Application for a non-material amendment following a grant of planning permission.

Unit:		House number:		House suffix:	
House name:					
Address 1:	BARNHAM COMMUNITY HALL				
Address 2:	YAPTON ROAD				
Address 3:					
Town:	BARNHAM				
County:					
Postcode (optional):	PO22 0BD				
Description of location or a grid reference. (must be completed if postcode is not known):					
Easting:		Northing:			
Description:

REPLACEMENT VILLAGE HALL WITH THE ERECTION OF A TERRACE OF
4 NO 2 BED HOUSES AND 4 NO 3 BED HOUSES ON FORMER
VILLAGE HALL SITE

BN / 3 / 09

| Drawing Title:<br>Site Plan                                                                                     |                    |                |          |

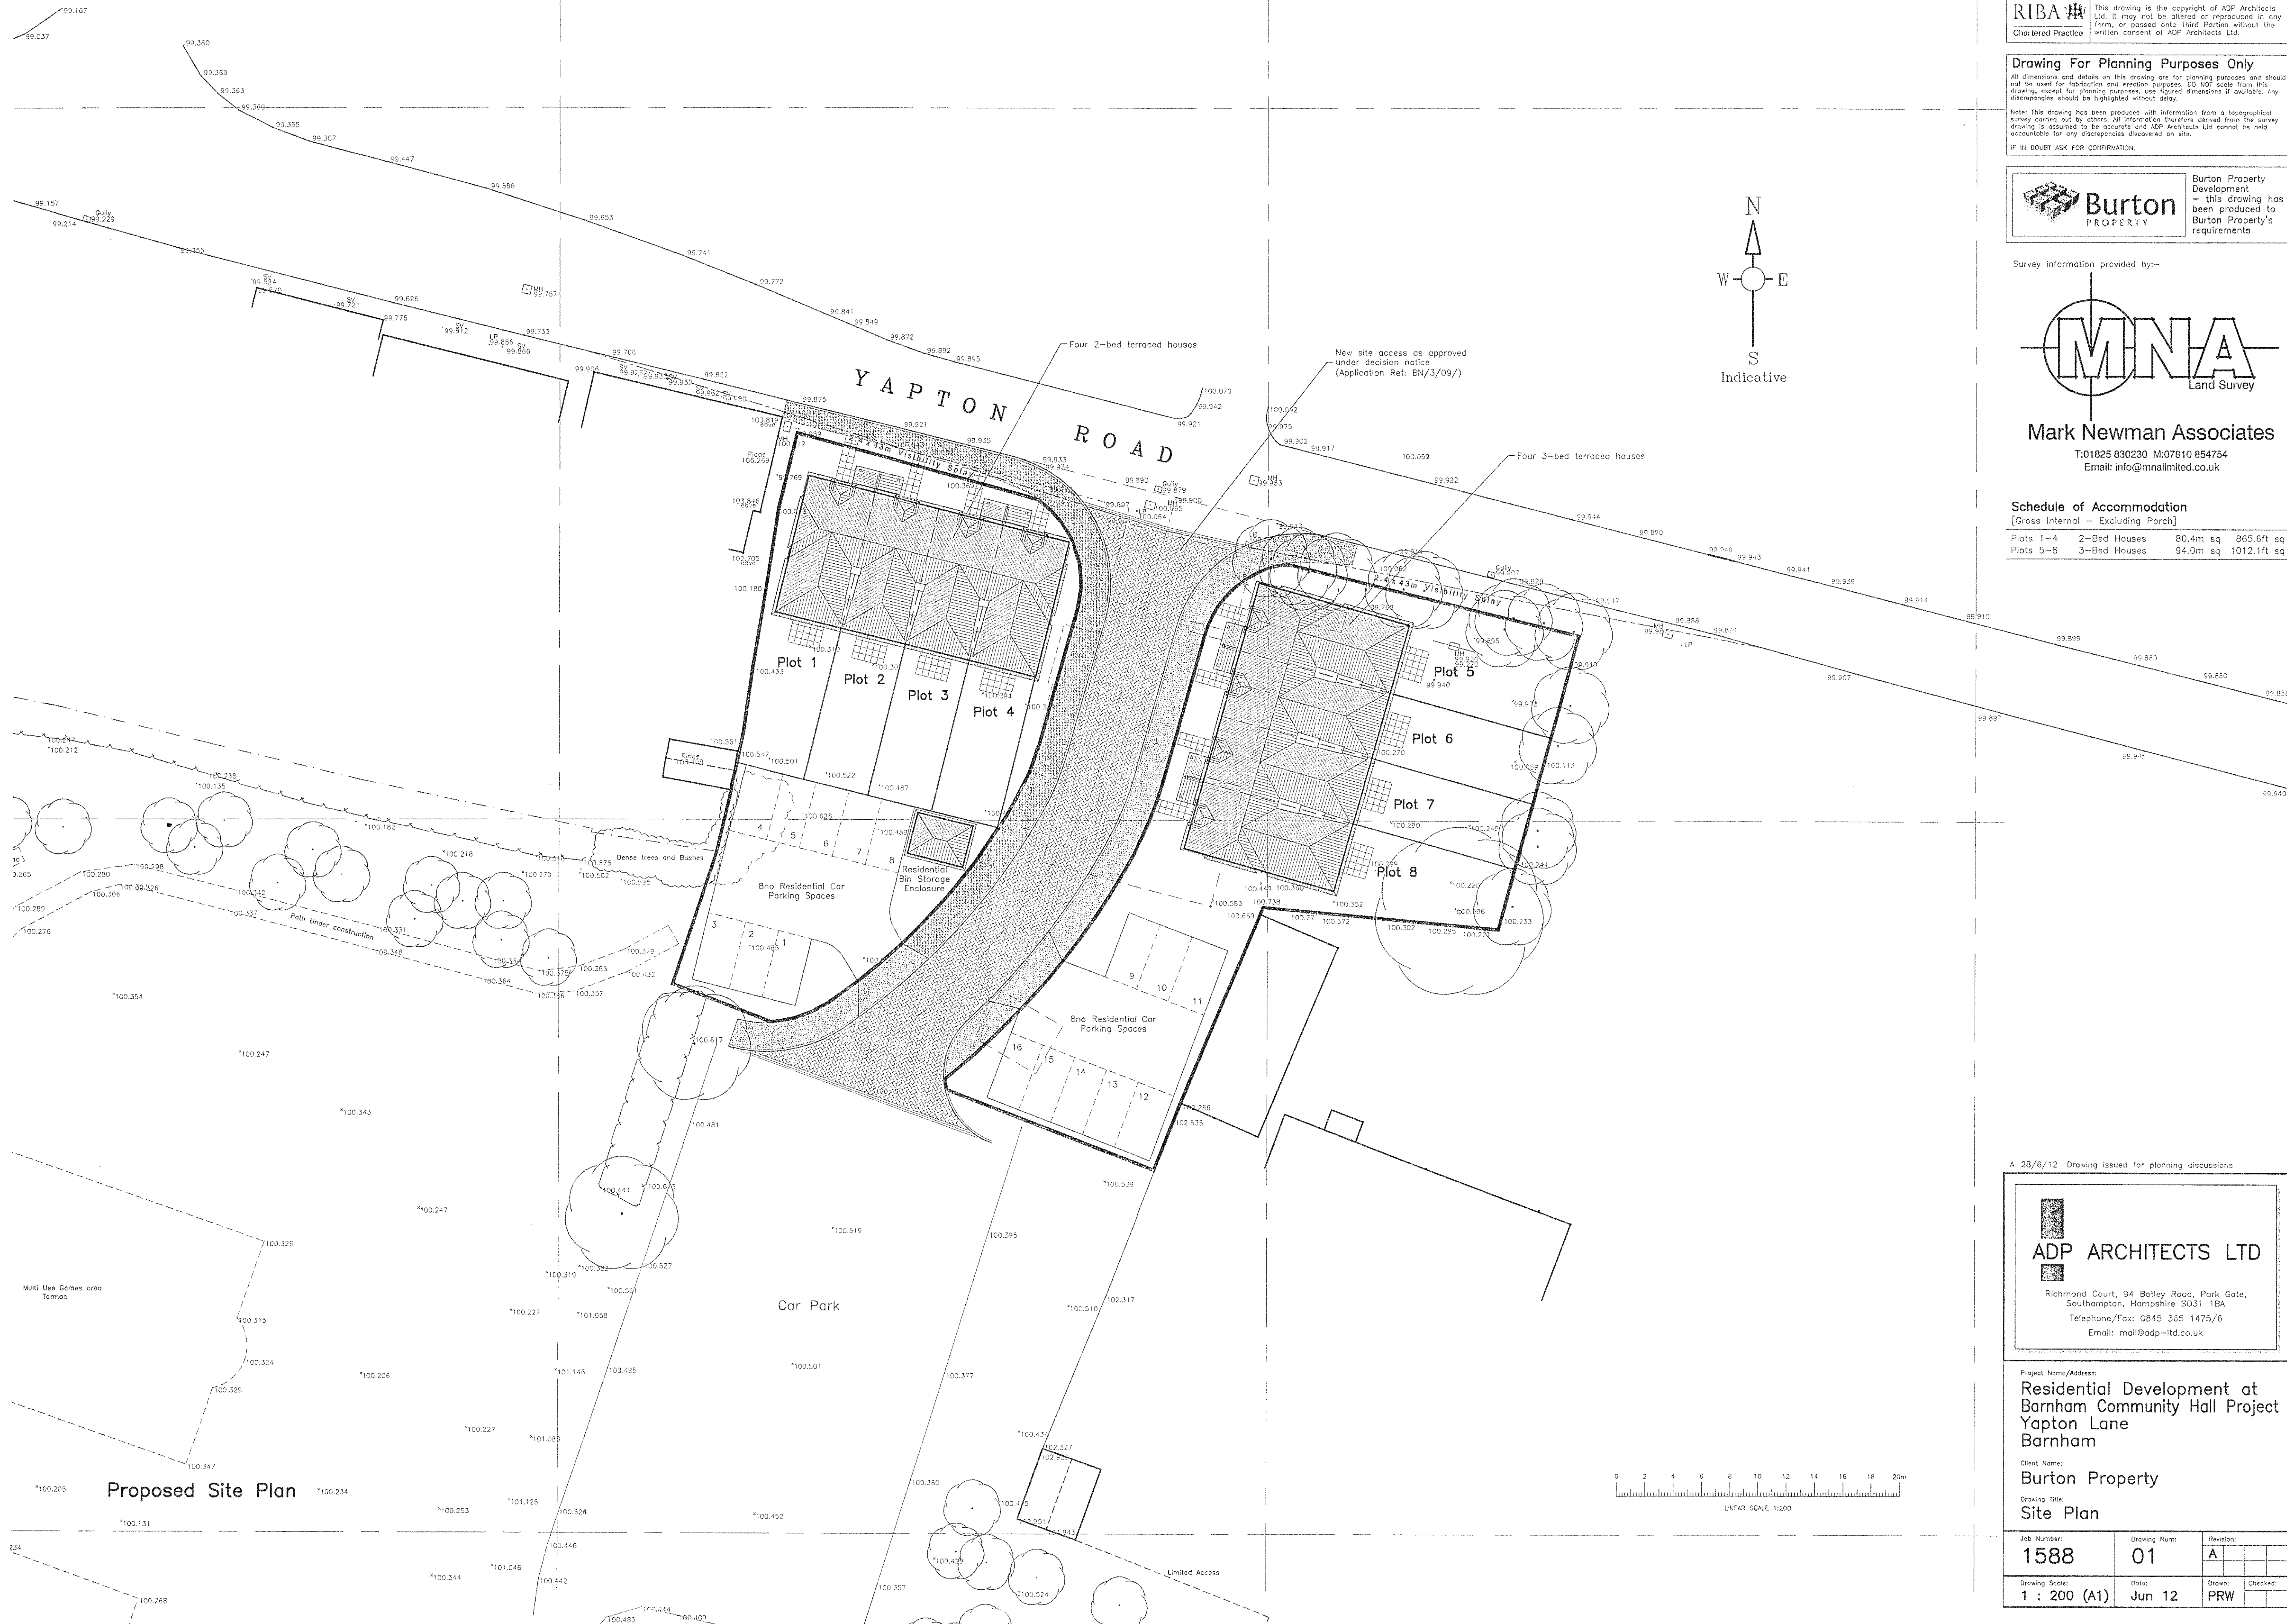
A MORE DETAILED SITE LAYOUT PLAN PRECISELY SHOWING
THE LAYOUT AND EXTERNAL ARRANGEMENTS + AN INTERNAL
WORKS LAYOUT SHOWING PROPOSED HARD AND SOFT TREATMENTS
TO BE READ IN CONJUNCTION WITH TGD LANDSCAPE PLAN 1912-101
SUBMITTED TODAY TO DISCHARGE CONDITION 11
